Subject: Planning Consultation on: A/234/21/DOC

Response to Planning Application

Description: Approval of details reserved by condition imposed under A/125/13/ relating to condition 17- landscape scheme

Location: Chandlers BMW Worthing Manor Retail Park Rustington BN163FH

scheme: Mill Lane Site
client: Group 1 Automotive
drawing: Landscape Re-planting
date: October 2021
scale: 1:200@A1
drawing no: STORE18832 30 Sheet 1
drawn: LS checked: DKM

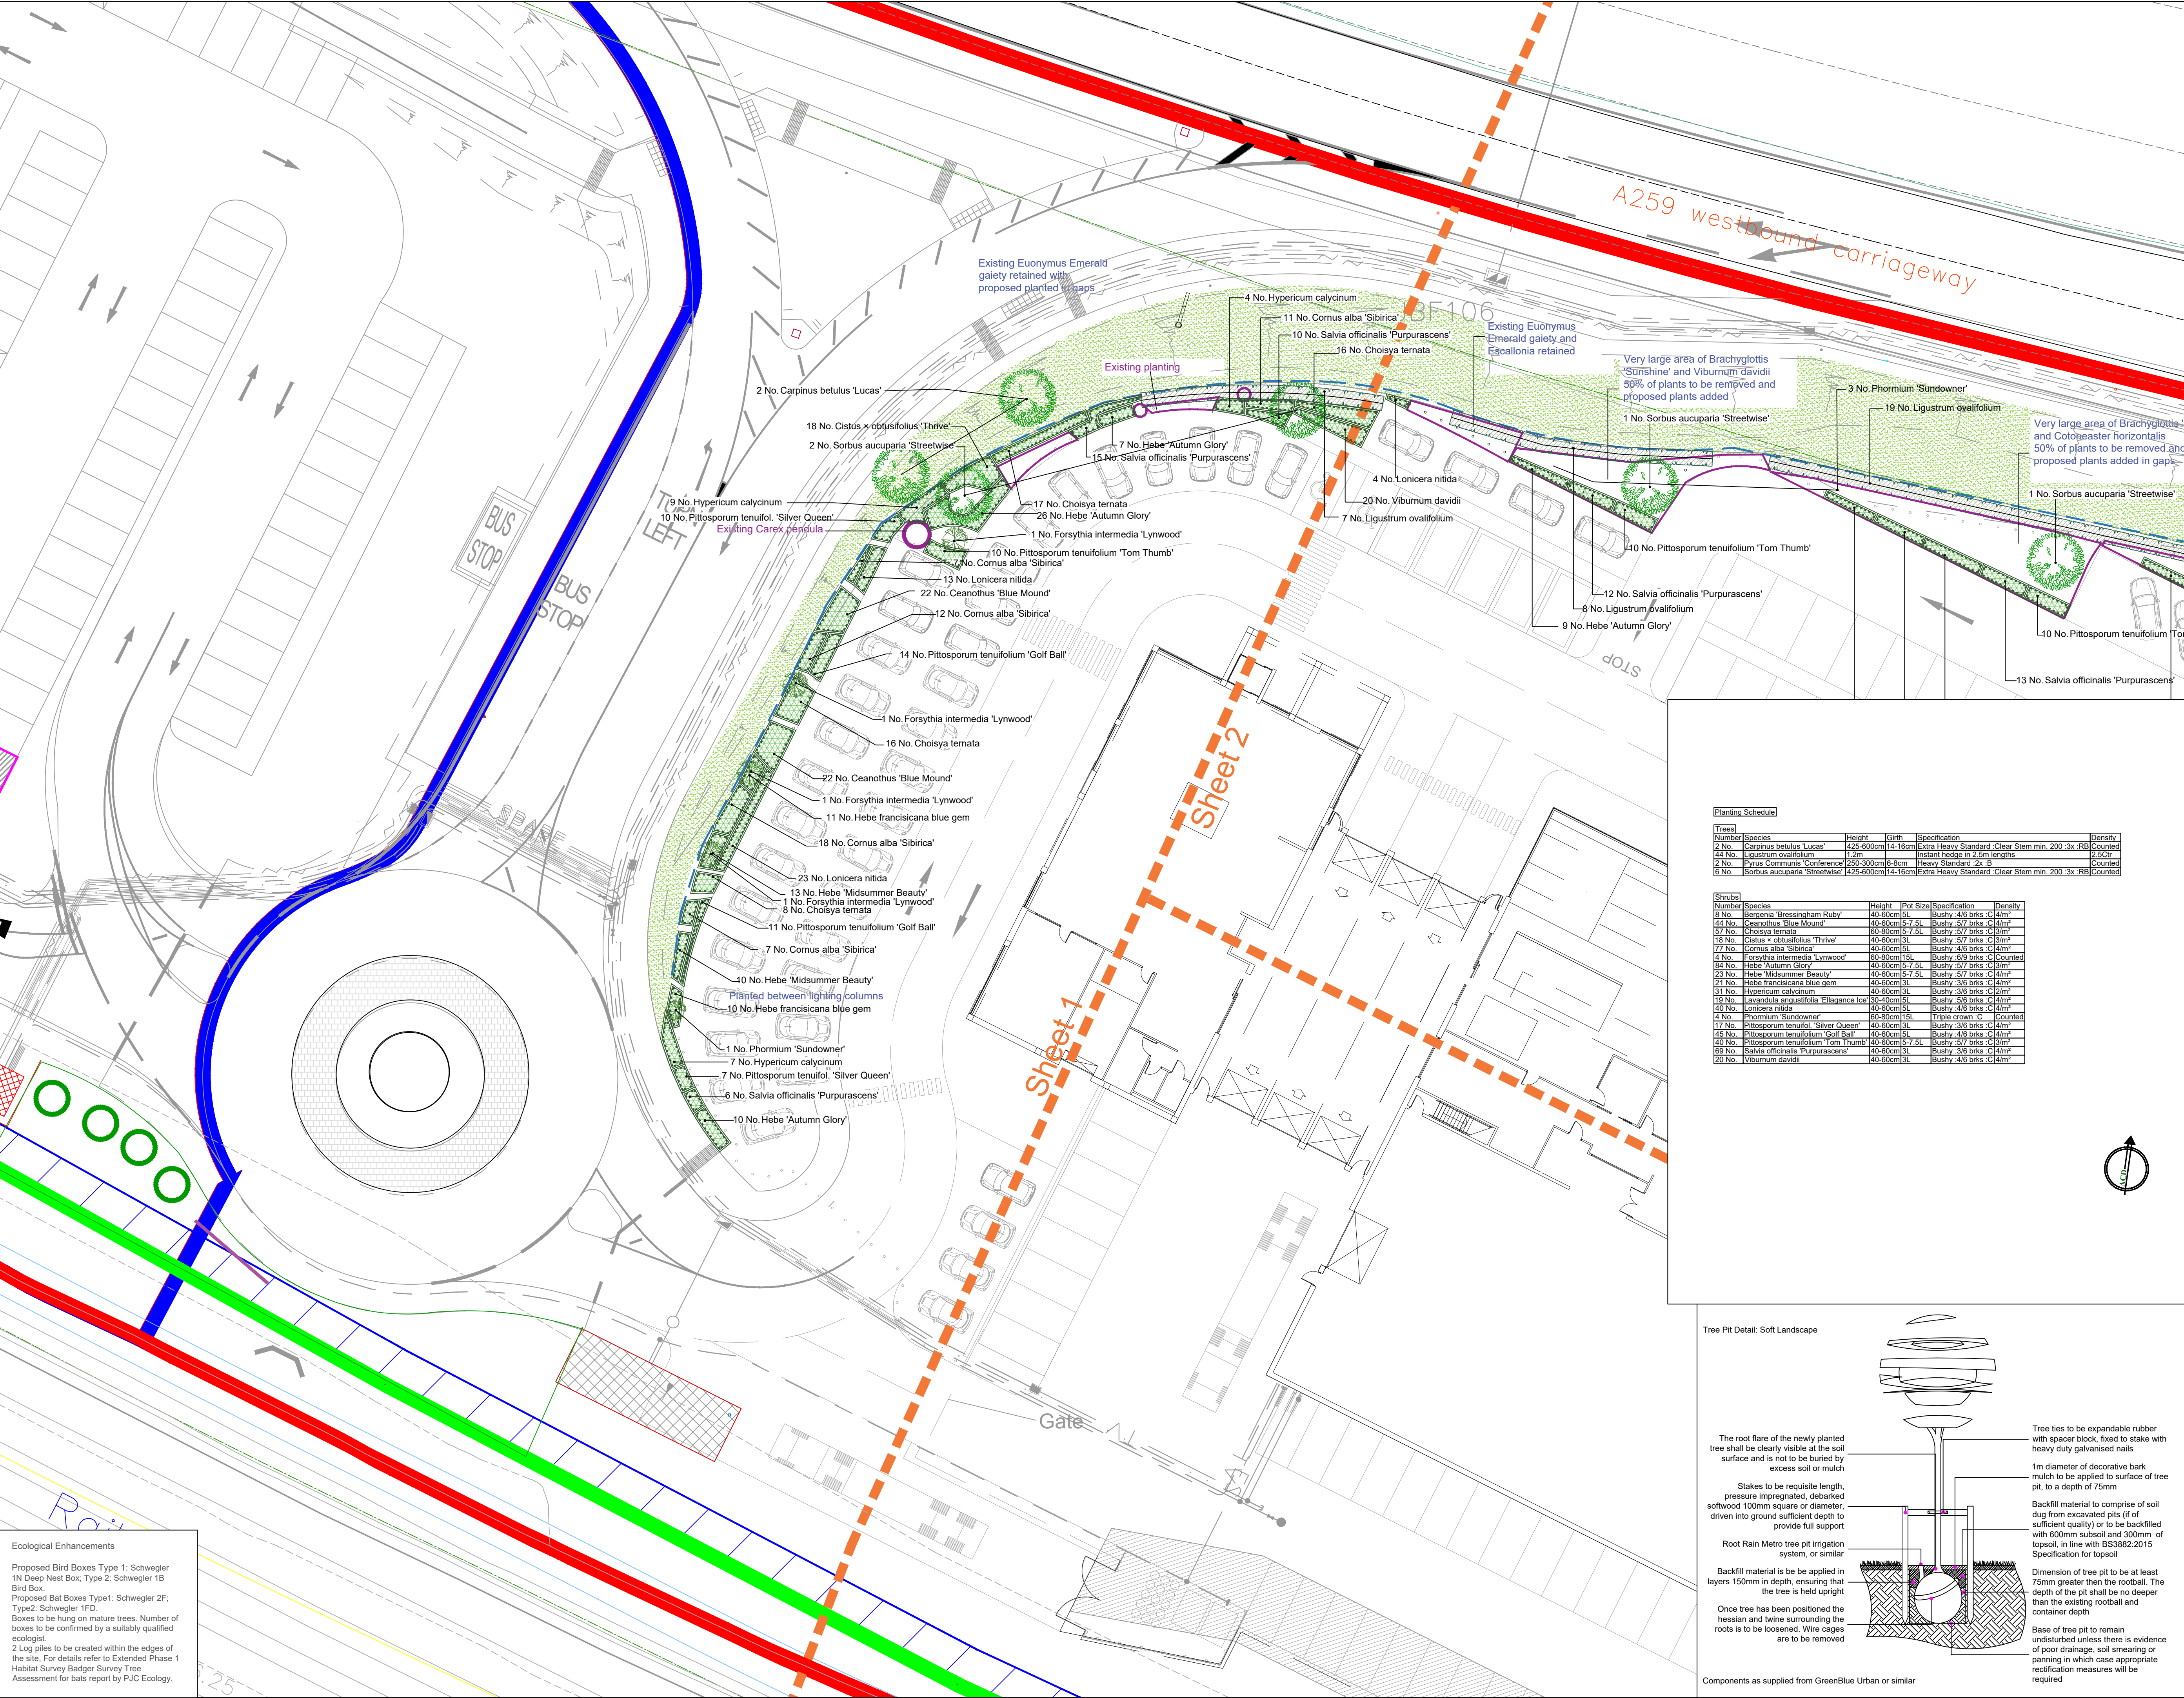
Landscape Re-Planting Dwg No STORE18832 20 Sheet 1 and Re-Planting Dwg No STORE18832 20 Sheet 2 has now indicated a total of 10no trees to the north and western aspects of the building frontage. Only 5no size 14-16cm girth to the frontage with 3no 14-16 to the western area and 2no further size 6-8 cm girth to the eastern frontage.

These specified trees are still inadequate in quantity, location and specified size and have failed to address the proposed outline scheme previously submitted and still fails to address the mitigation for trees removed and the screening requirement on this section of the development parcel.

44no Ligustrum ovalifolium are also listed under trees for this frontage area, these are misleading as these are not trees (in any screening sense) but hedging proposed at an install and maintenance height of 1.2m and which will do nothing to add softening or screening to this frontage and minimal biodiversity benefit to this location.

The large hardstanding vehicle parking areas have not received any landscape consideration or proposal (devoid of any tree planting proposals) and which still contradicts that shown at outline.

The previous application A/157/21/DOC indicated minimal and inadequate tree planting (6no std Birch 10-12cm) also to the rear of the building these appear to have now been omitted entirely from these proposals, this area also needs to be addressed and included within the proposal for the site.

Areas of existing groundcover mono block shrub planting along the site frontage have been proposed for removal and the introduction of a wider variety of shrub species introduced is seen as an improvement, however these still remain largely low growing species which again whilst improving biodiversity habitat will not add to the screening or softening of the building. The introduction of mid height shrubs and shrubby tree species need to be provided particularly along the western access road section.

The revised scheme re-submitted under this application A/234/21/DOC in Re-Planting Dwg No STORE18832 20 Sheet 1 and Re-Planting Dwg No STORE18832 20 Sheet 2 remains in contradiction to the detail shown under Landscape Proposals Store 18832 14A dwg and still proposes a poor and inadequate landscape scheme for this site and location. This is particularly in reference to the inadequate proposed tree planting proposals which still fail to represent the detail which was provided within the approved application and which still fail to enhance and soften the site, fitting the location and in keeping with the adjacent scheme to the west of this site.

These revised proposals have provided insufficient trees in quantity and specification and have failed to take into account that the tree sizes need to be specified at a size which represents the loss of growth potential since the building was completed exceeding the EHS Extra heavy size specification.

scheme: Mill Lane Site
Rustington
client: Group 1 Automotive
drawing: Landscape Re-planting
date: October 2021
scale: 1:200@A1
drawing no: STORE18832 30 Sheet 3
drawn: LS checked: DKM

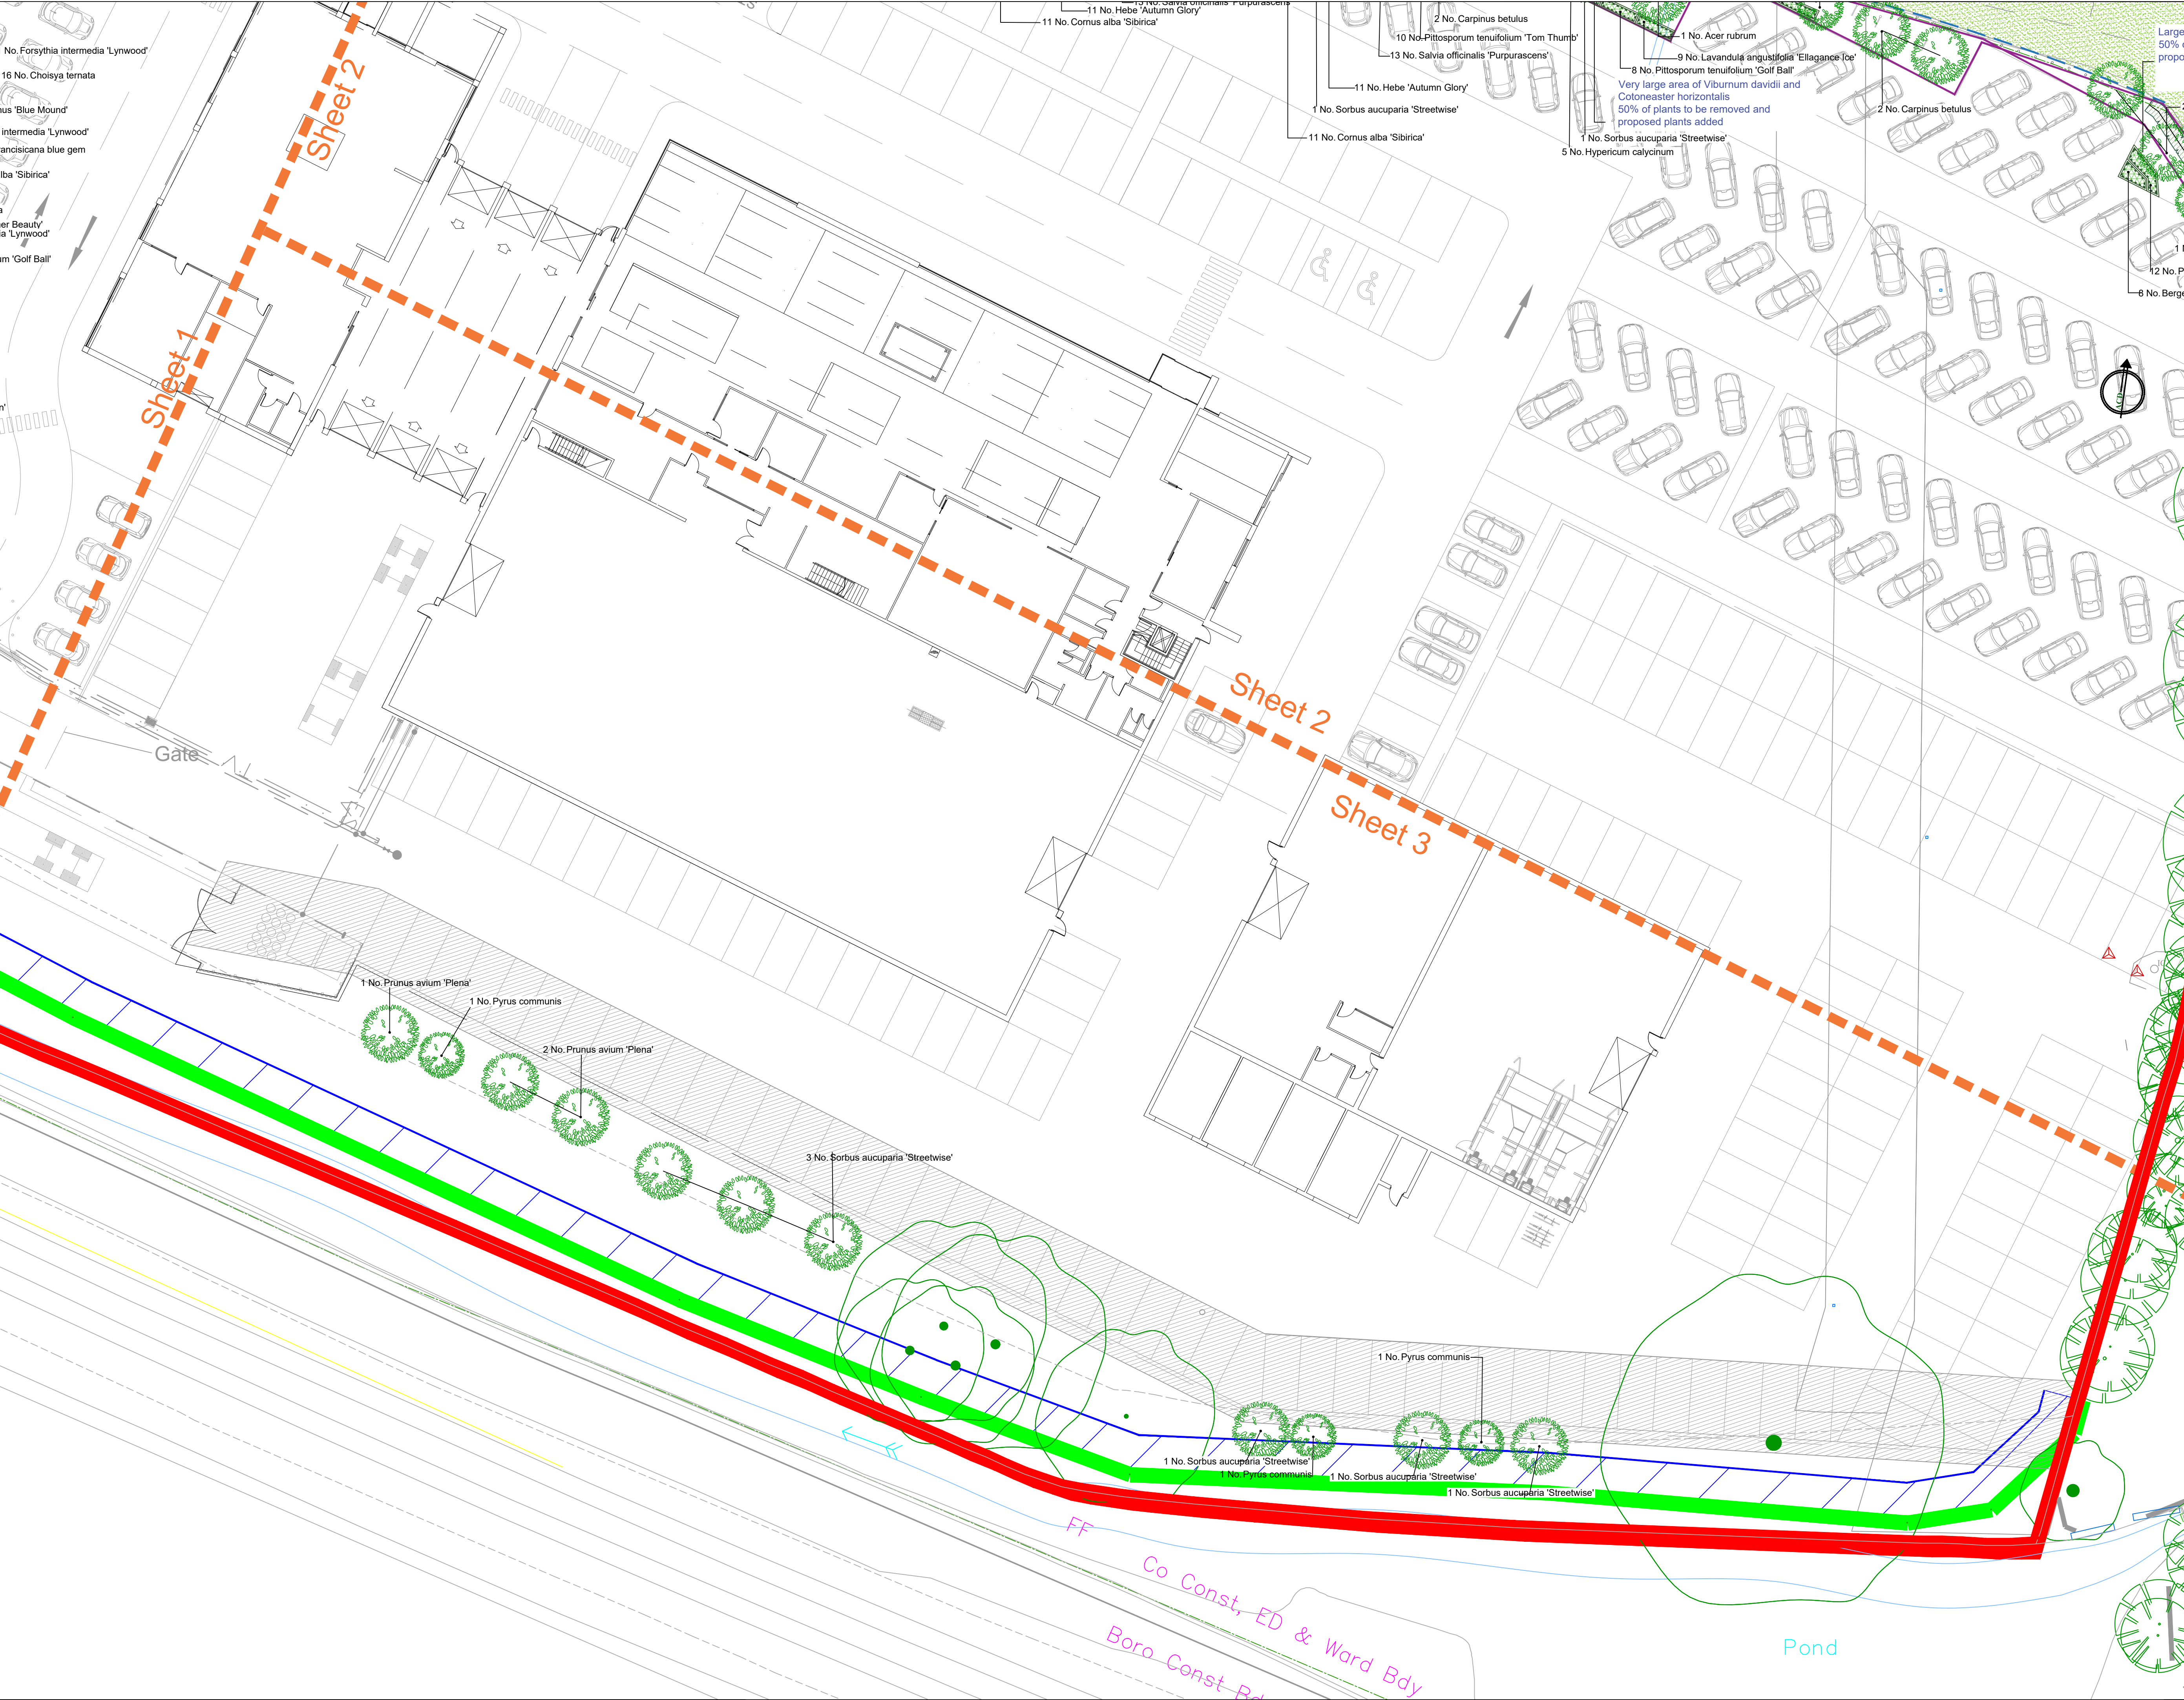
I had not been issued with Dwg No STORE18832 **30 Sheet 3**, however having now also viewed this one it brings no further to the frontage scheme only showing 2no Prunus avium Plena, and 2no Sorbus aucuparia Streetwise (no size given) to the rear of the building – but these don't feature in the plant schedule on Sheet 1? Do these form part of the proposal? Are these to replace/in addition to the previously shown Birch to the rear? This information needs to clearly be shown in plan and list form if to be considered as part of the proposal.
